Application Ref:	3/2021/0391	 Ribble Valley Borough Council www.ribblevalley.gov.uk
Date Inspected:	29/06/2021	
Officer:	AB	
DELEGATED ITEM FILE REPORT:		APPROVED

Development Description:	Regularisation of alterations carried out to rear garden area.
Site Address/Location:	14 Waverley Road Ramsgreave BB1 9BN

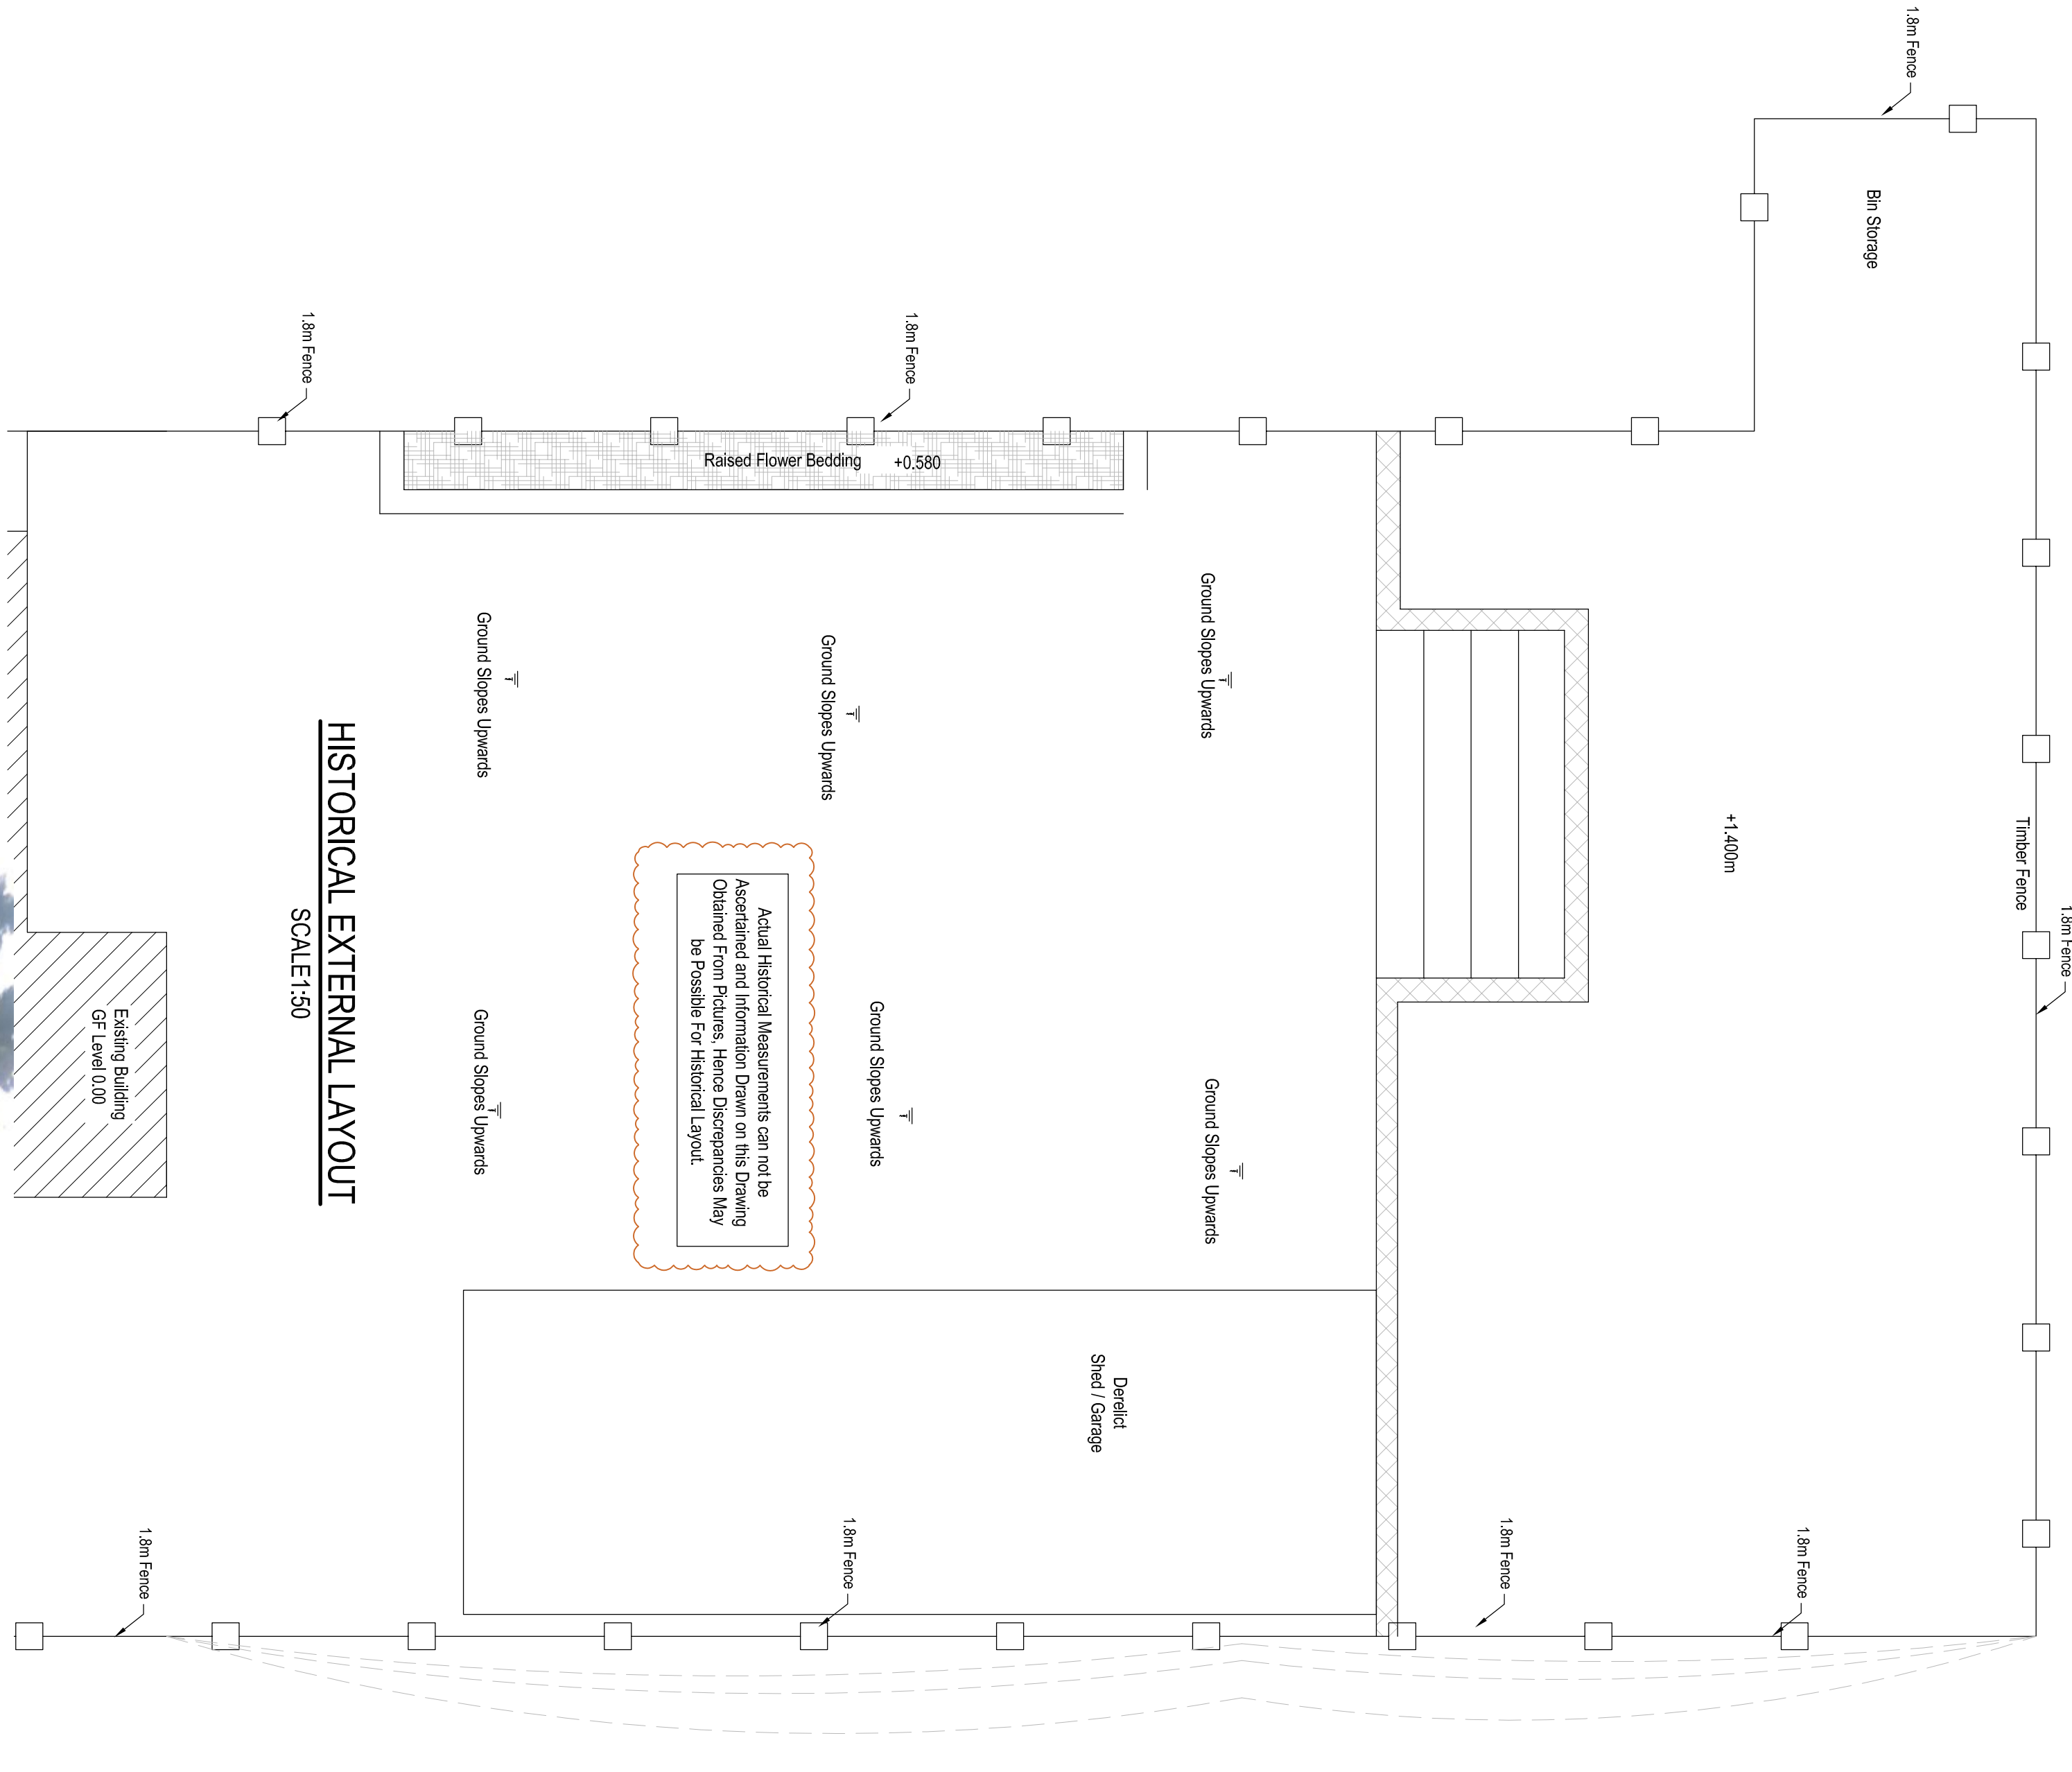
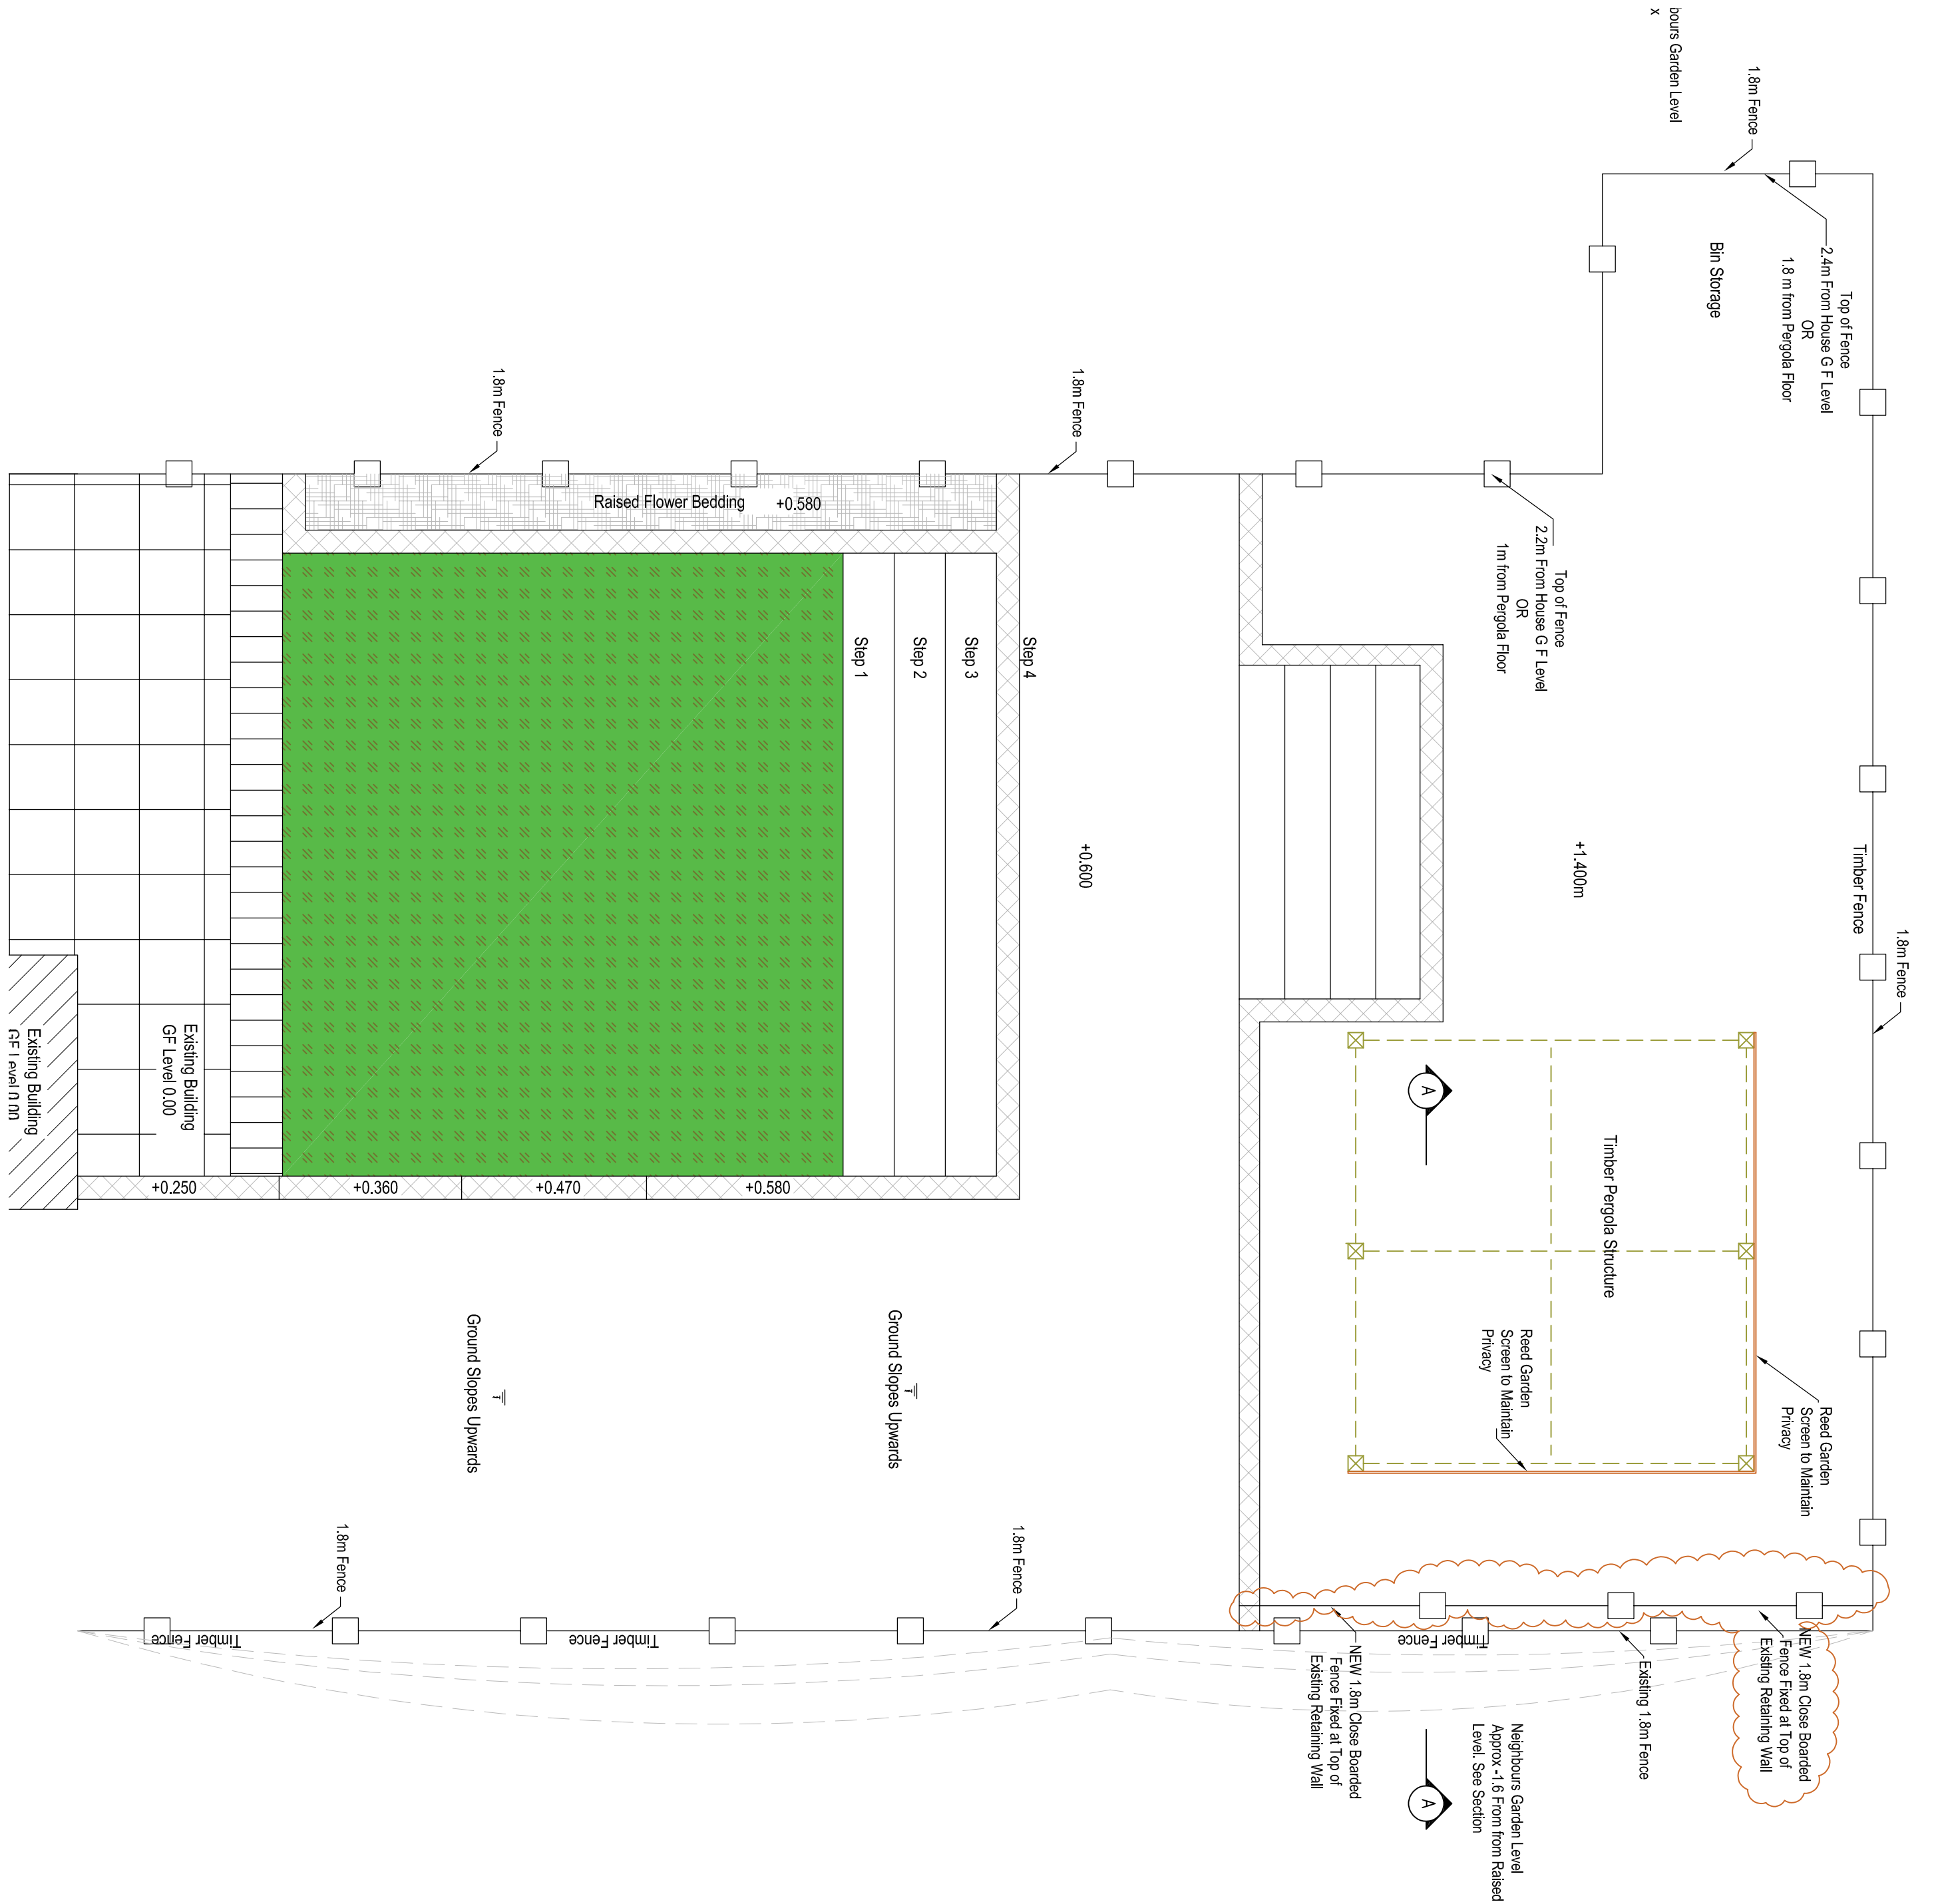
Regarding levels to the rear of the site, it does not appear that land has been raised notably at this point due the consistent height of the land when measured against the concrete panels of the rear fence as shown on submitted before and after photos. However, objectors have provided a range of information to demonstrate the previous site layout. Taking this into account it is considered that, on the basis of probability, the raised area of land to the rear of the application site has been considerably extended to create a large level platform that would provide unrestricted, elevated views into the neighbouring garden of 16 Waverley Road.

In order to prevent harmful overlooking resulting in a loss of privacy it is recommended that the applicant erect a 1.8m high boundary treatment along the northern edge of the raised platform with height measured from the raised platform. The boundary treatment would thereafter be retained and maintained at all times.
